RETREAT AT TIMBERRIDGE FILING NO. 2
RESPONSES TO COMMENT LETTER DATED JULY 6, 2021
SF-21-021
OCTOBER 6, 2021

FINAL PLAT COMMENT LETTER

RETREAT AT TIMBERRIDGE
FILING NO. 2
JOB NO. 1185.20
JANUARY 4, 2021
SHEET 6 OF 7

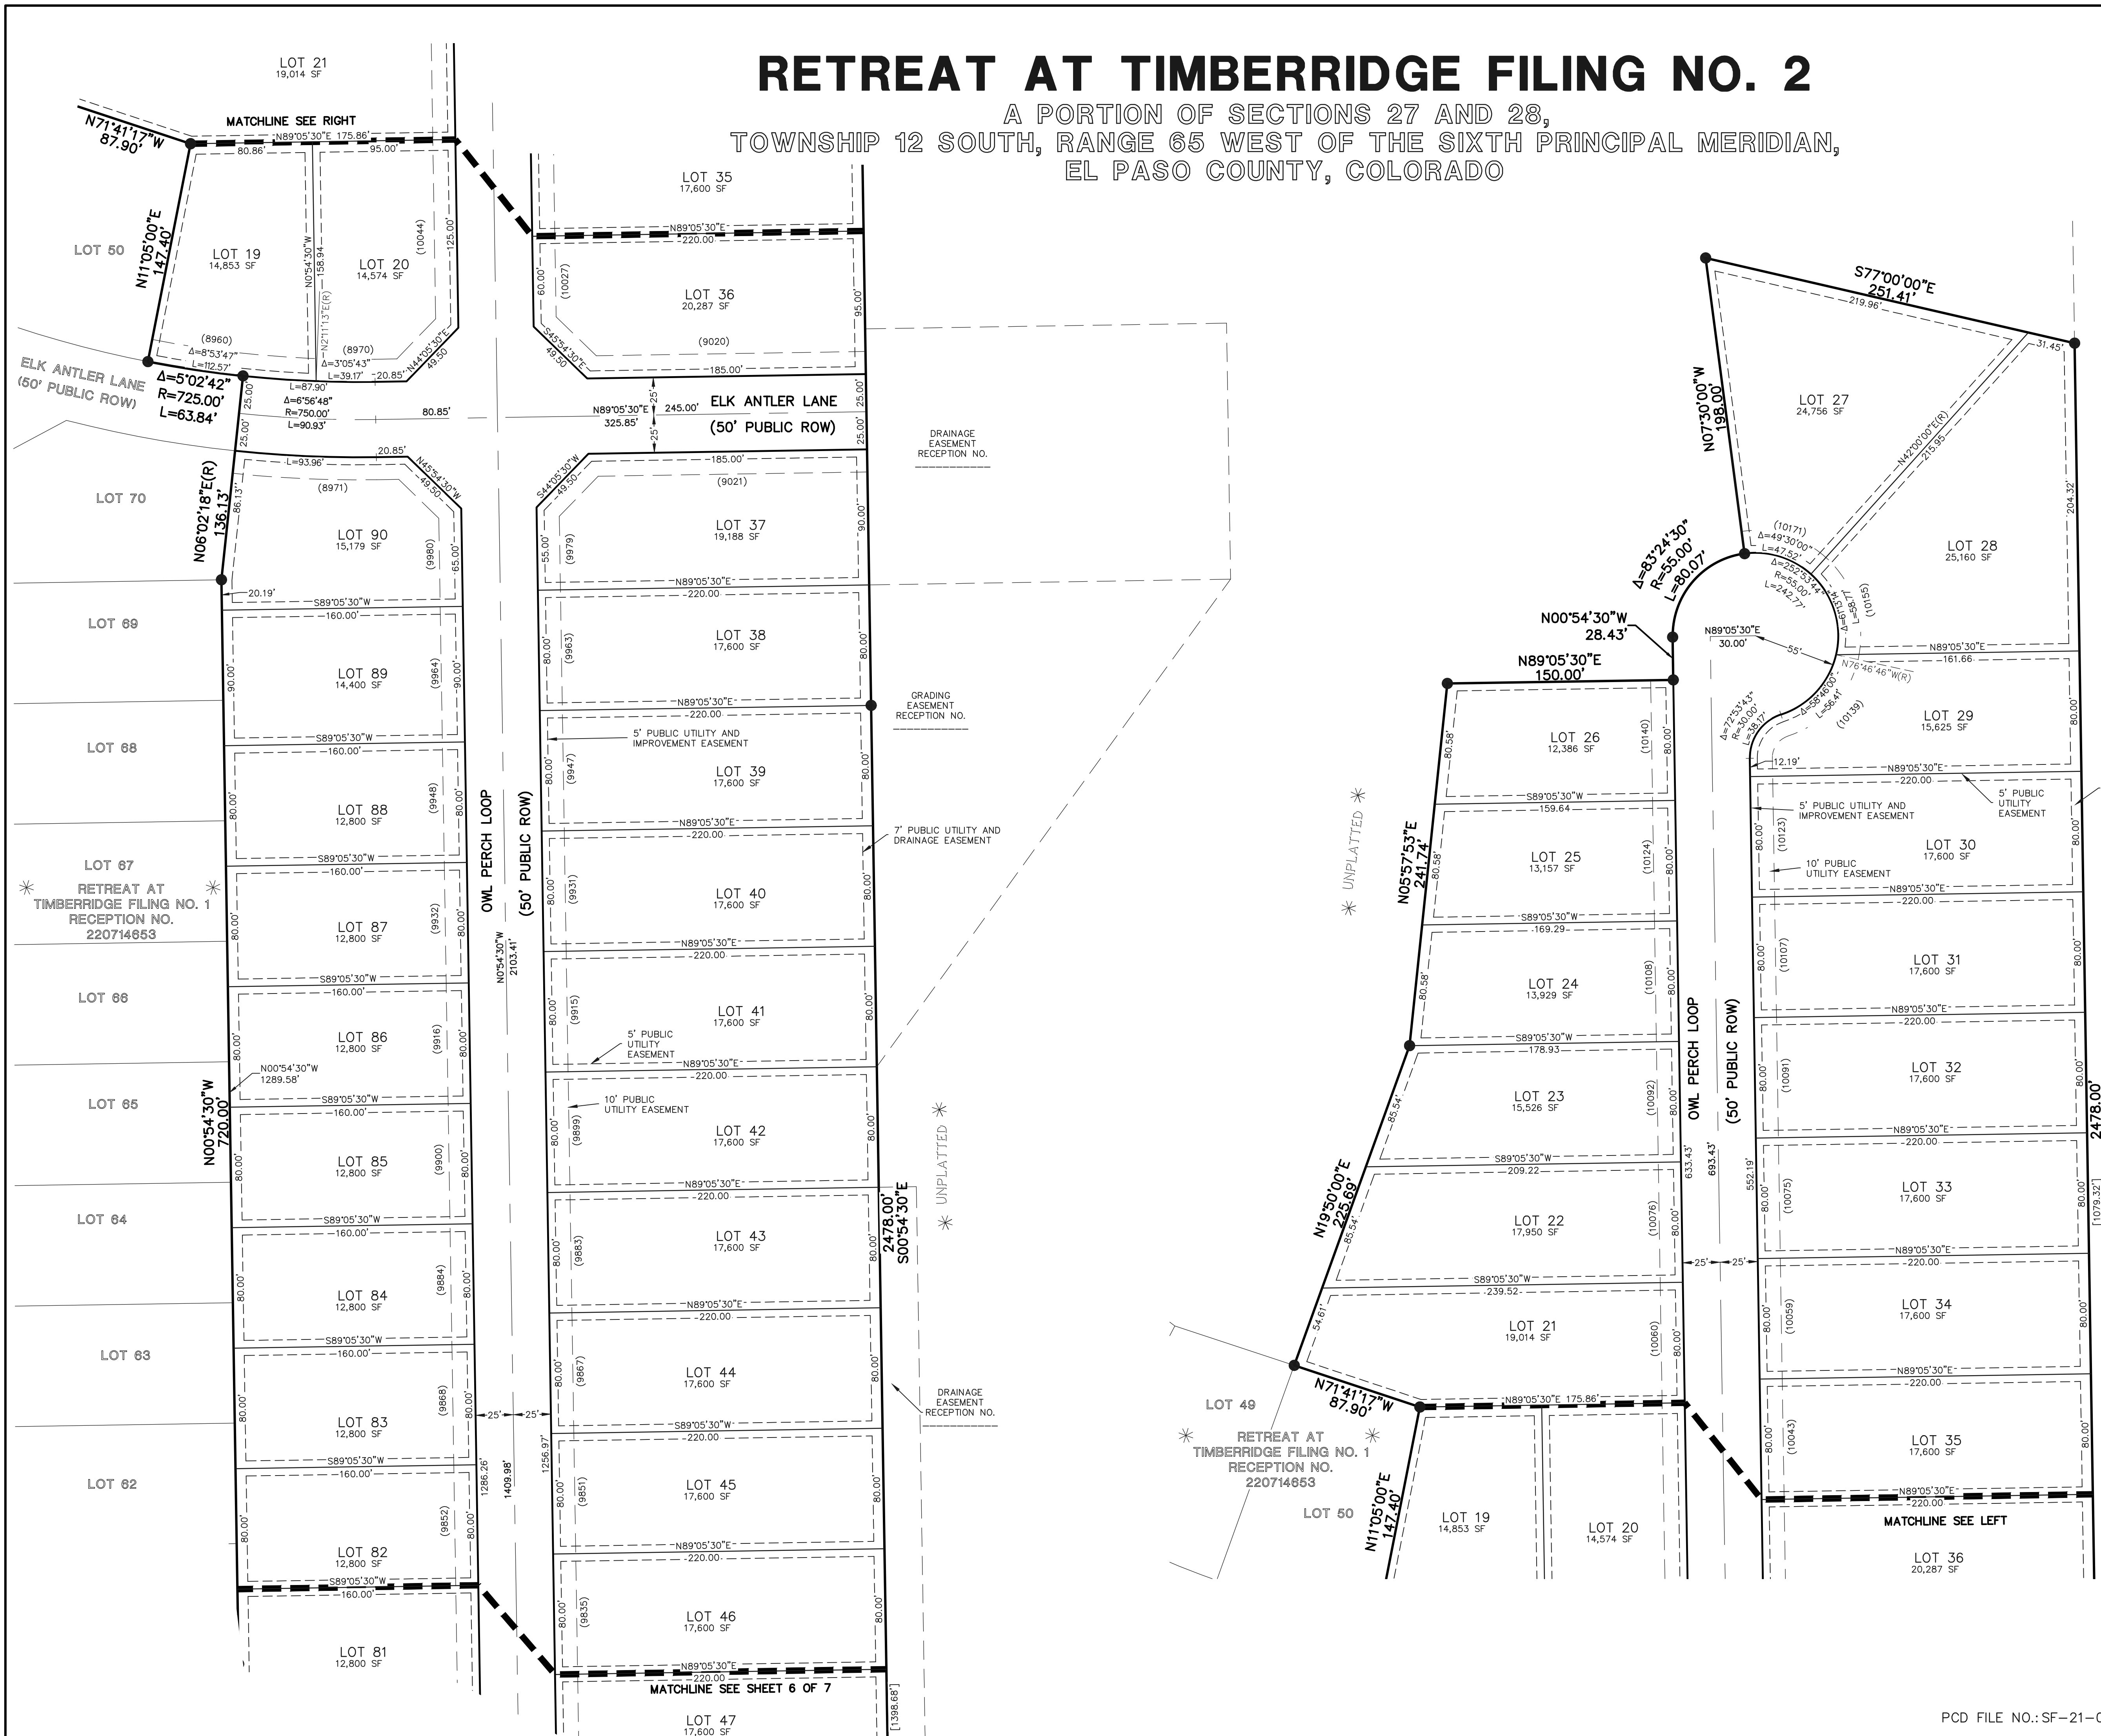
- THE DRAINAGE EASEMENT IS ON PROPERTY TO THE EAST OF THE PLAT BOUNDARY. THE EASEMENT WILL BE GRANTED BY SEPARATE DOCUMENT AS IT IS NOT WITHIN THE BOUNDARIES OF THE PLAT.
- AS THE DRAINAGE IS EAST OF THE REAR LOT LINES HAVING THE FENCE ON THE PROPERTY LINE WILL NOT INTERFERE WITH THE DRAINAGE.
- NOTE 38 HAS BEEN TO COVER THE CONSTRUCTION AND MAINTENANCE OF THE FENCE.
